Your Ref 23/00977/OUT

Friday 12 May 2023

Proposal: Outline Planning Application (except for access) for residential development of up to 60 dwellings (Use Class C3) including a community facility, new vehicular and pedestrian access off Claydon Road, public open space and associated landscaping, earthworks, parking, engineering works and infrastructure

Location: OS Parcel 9195, North of, Claydon Road, Cropredy

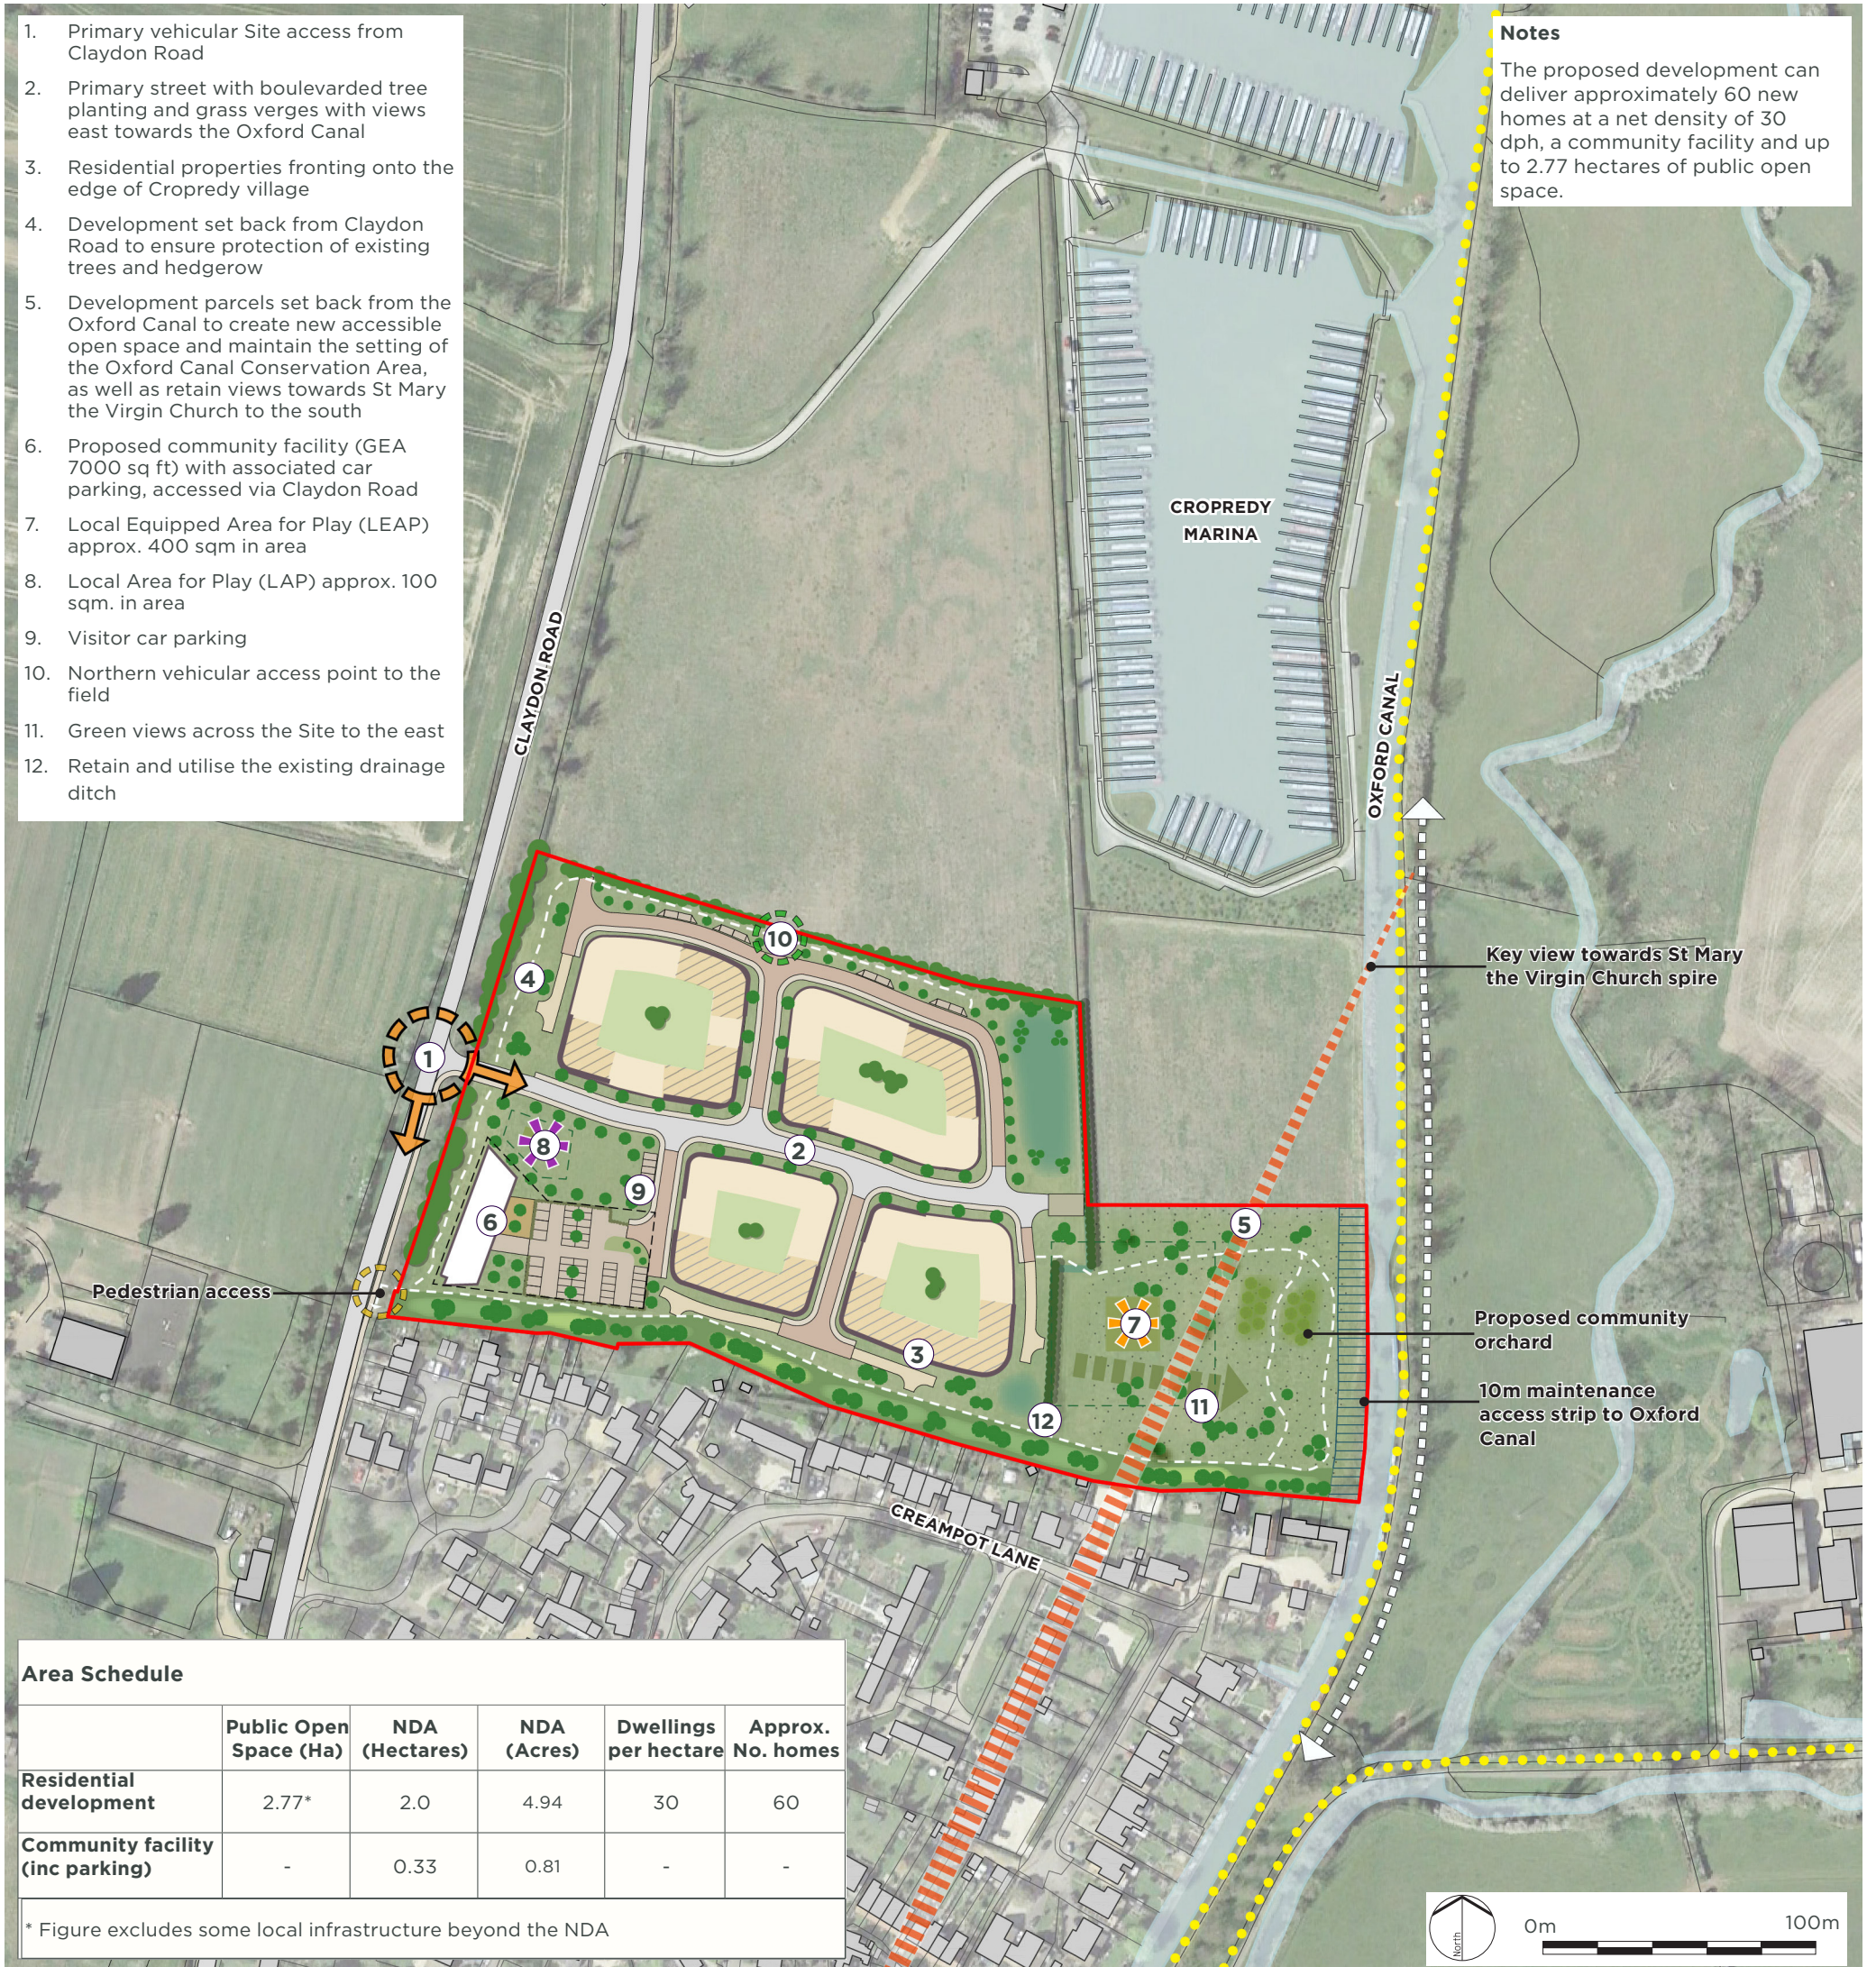
The illustrative plans show the area closest to the canal to comprise of an access road, garage block and the side of at least one house. This section of the site is poorly designed and could be improved by moving the access road to the rear, making the parking more discrete and by ensuring houses front the open space improve passive surveillance of the public open space.

The retention of the field boundary hedgerow to the east of the proposed housing is crucial to help screen the development from the waterway and it may help screen the road and parked vehicles, but this is unclear without cross sections. However, the boundary hedge also obscures views of the play area from the houses. By bringing the houses further forward with the road behind this may be improved.

A wildflower meadow is proposed adjacent to the canal with a 10m buffer to the canal for maintenance and to ensure that the recreational impacts on the canal's wildlife are minimised. It is not clear what will happen in this 10m buffer, will it be planted or left as scrub? Who will maintain this area of land in the future as it will not form part of the Canal & River Trust's ownership. Will it be planted with suitable canalside species? Further information should be included as part of a detailed landscaping plan.
